PROJECT REFERENCE NO.	1-5878
SHEET NO.	UC-14
DESIGNED BY:	DMP
DRAWN BY:	DMP
CHECKED BY:	DMP
APPROVED BY:	
REVISED:	
NORTH CAROLINA DEPARTMENT OF TRANSPORTATION	
UTILITIES ENGINEERING SEC. PHONE: (919) 707-6690 FAX: (919) 250-4151	UTILITY CONSTRUCTION PLANS ONLY

REVISIONS
1. 06/21/2021 - ADDED FLUOROELASTOMER GASKETS TO PW700 FROM STA. 0+00 TO 6+50.

PROJECT REFERENCE NO. <b>W-5600</b>	SHEET NO. <b>UC-27</b>
DESIGNED BY: <b>SS</b>	DATE: <b>11/25/2019</b>
DRAWN BY: <b>SS</b>	
CHECKED BY: <b>MVZ</b>	
APPROVED BY: <b>MVZ</b>	
REVISED:	
NORTH CAROLINA DEPARTMENT OF TRANSPORTATION	
UTILITIES ENGINEERING SEC. PHONE: (919) 707-6690 FAX: (919) 250-4151

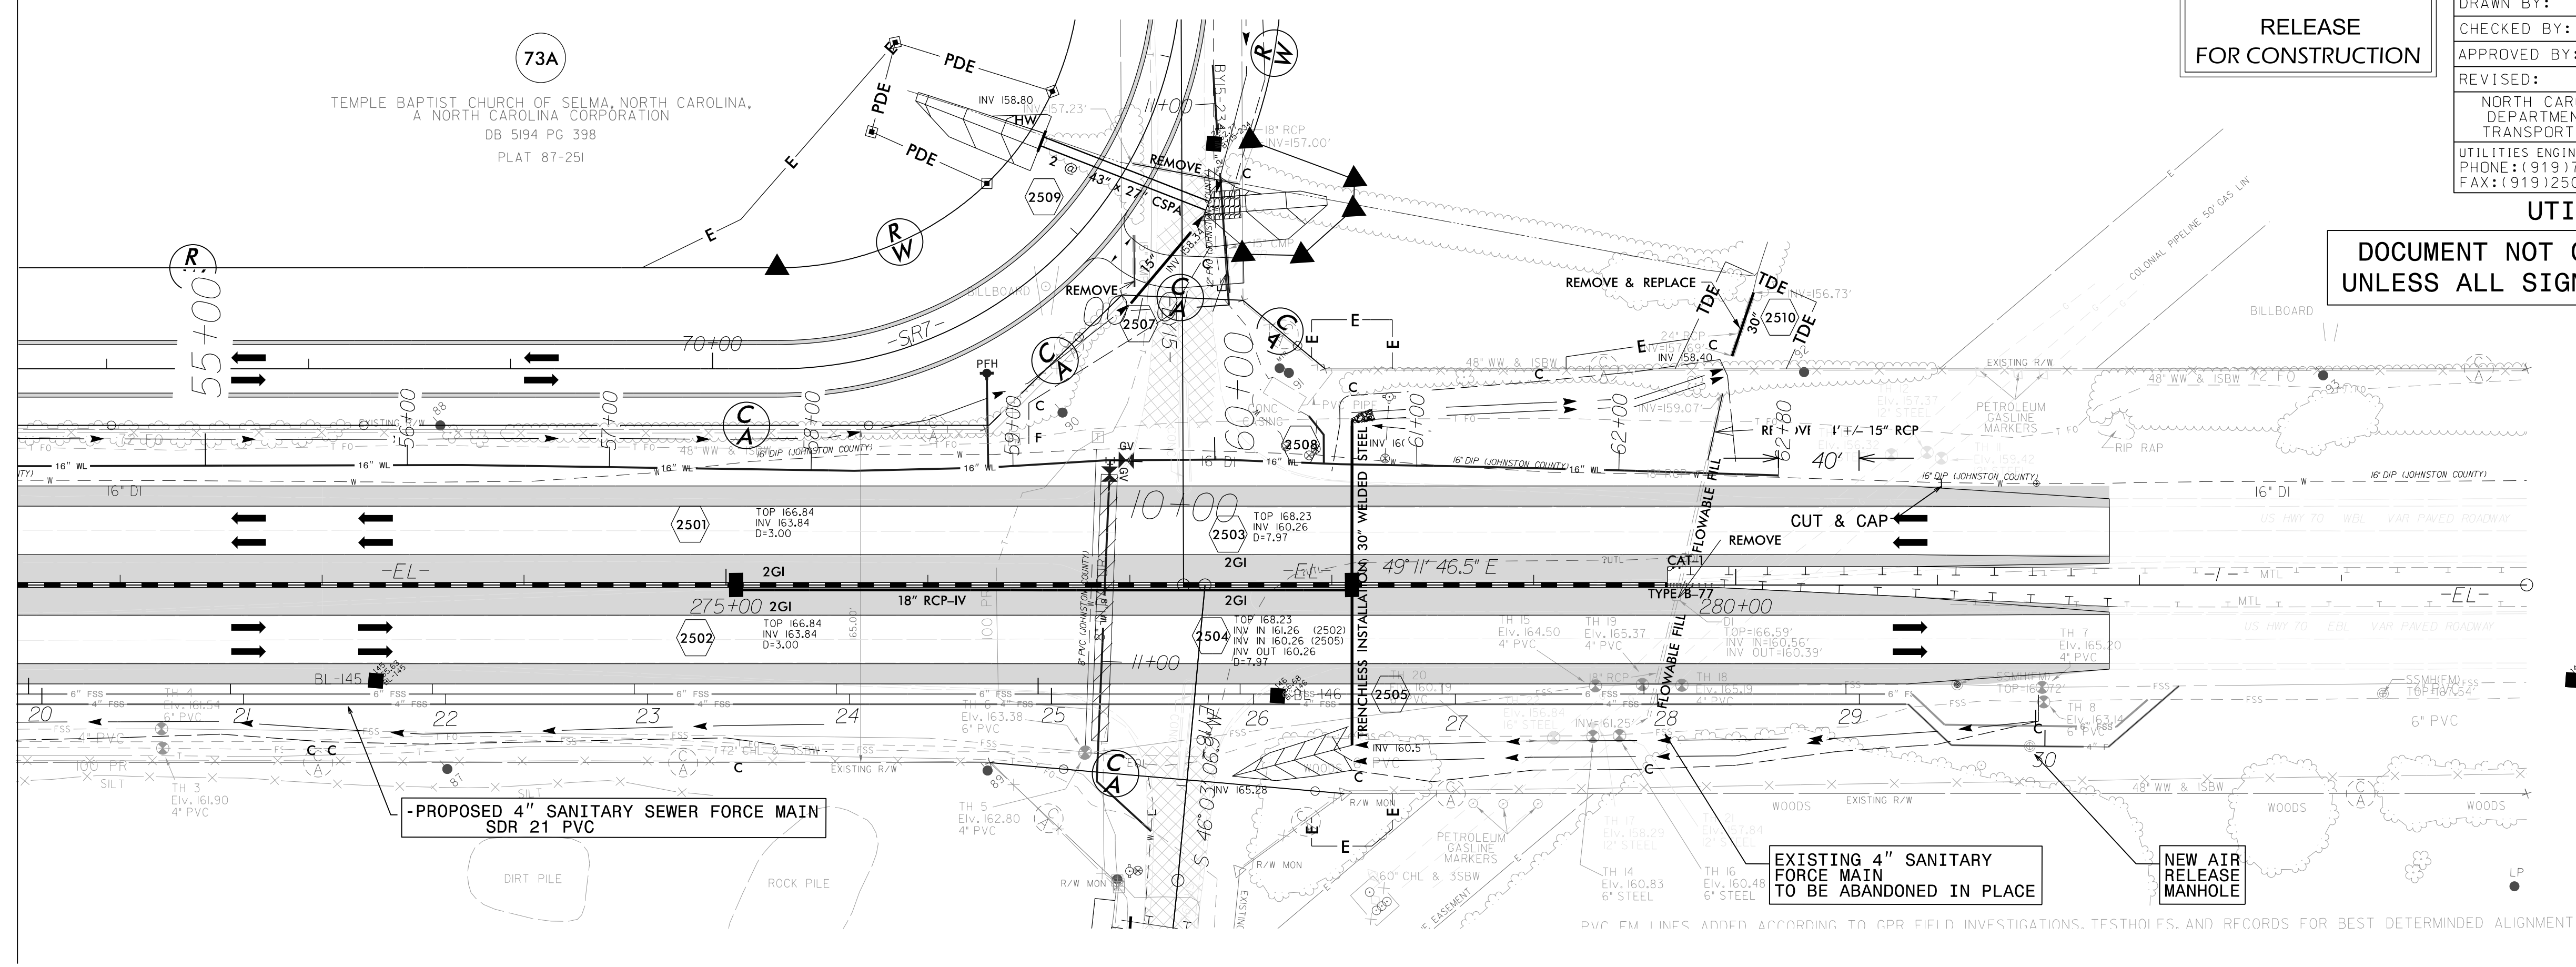
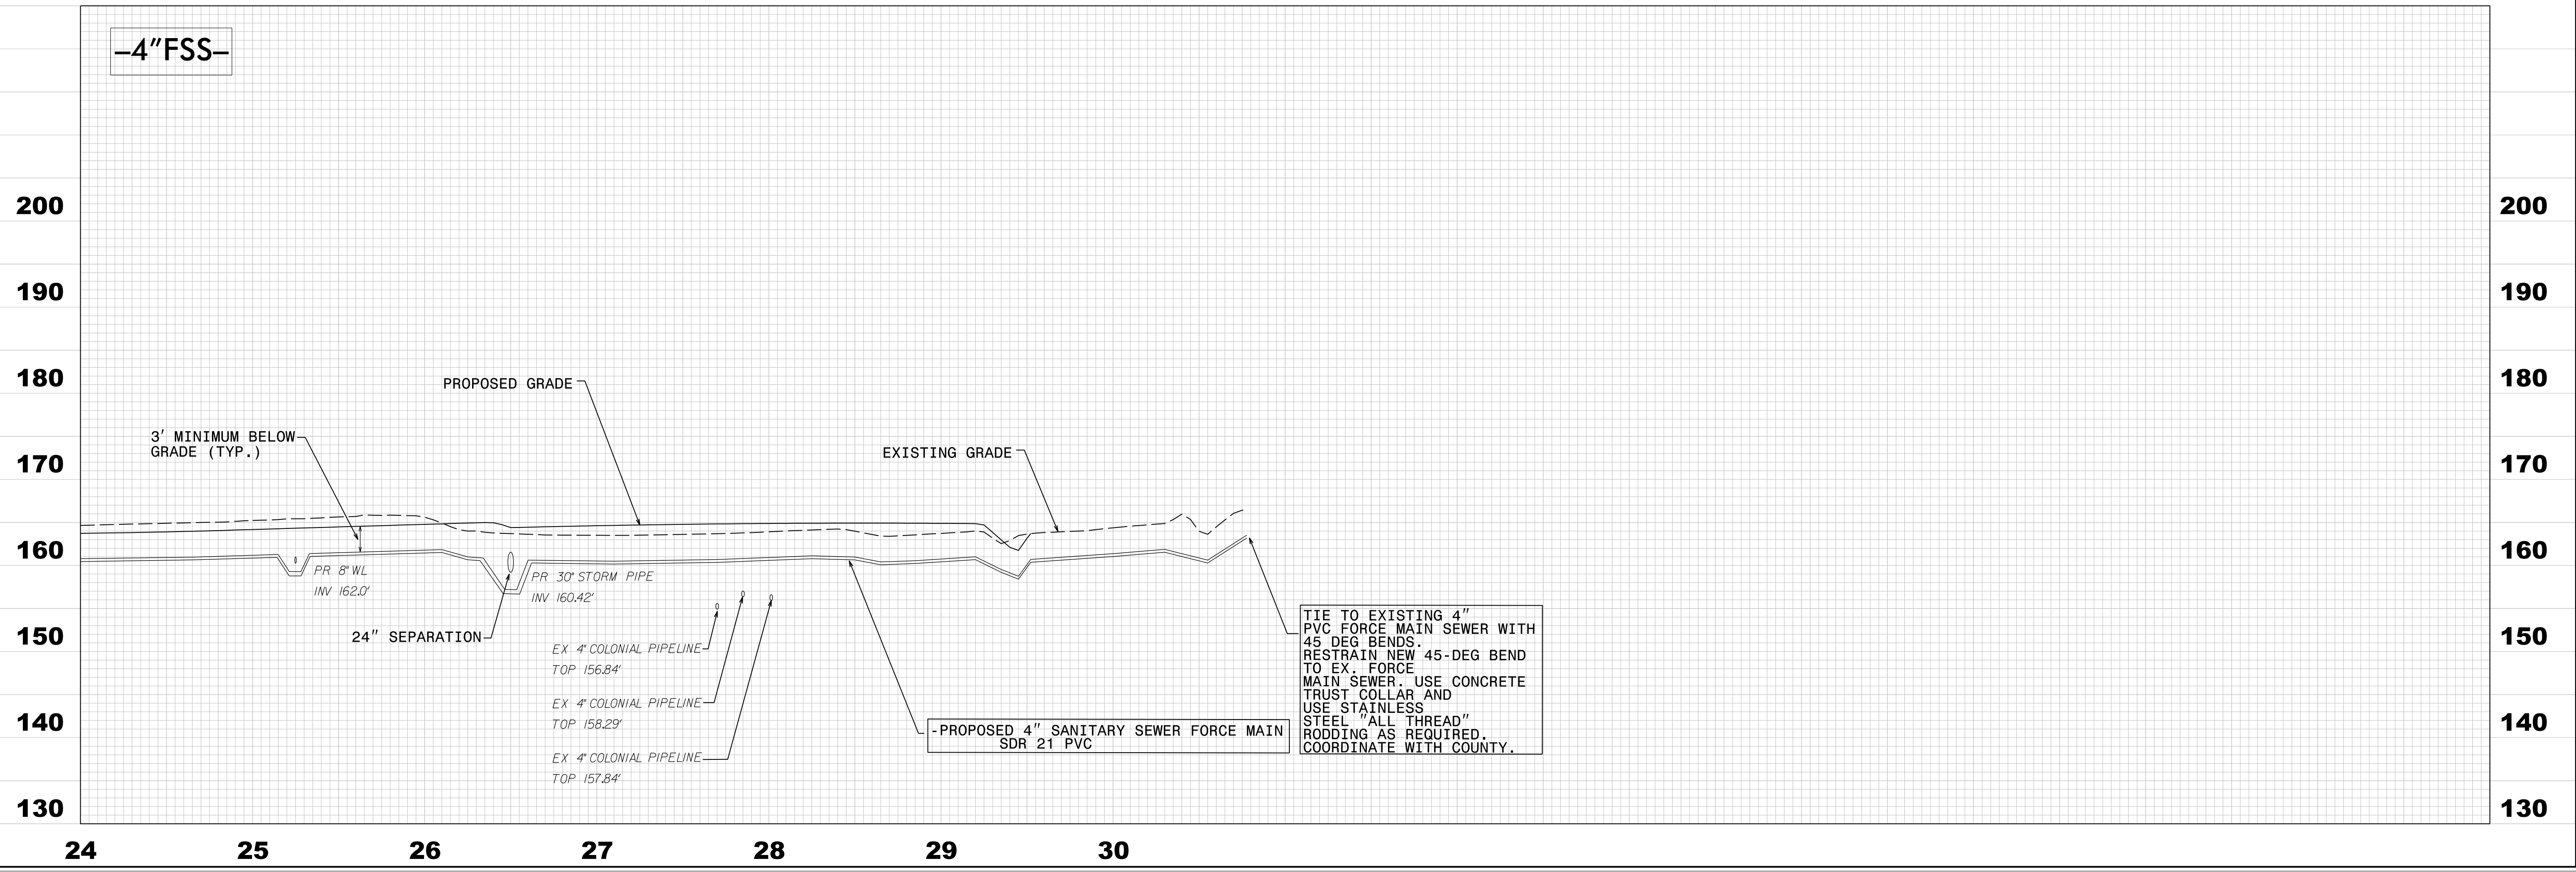
INSTALL DI PIPE, FLUOROELASTOMER GASKETS, & POLYWRAP AS SHOWN ON SHEET UC-27 (PW700 STA. 0+00 TO 6+50). ALL CONTAMINATED SOILS SHALL BE REMOVED AND DISPOSED OF.
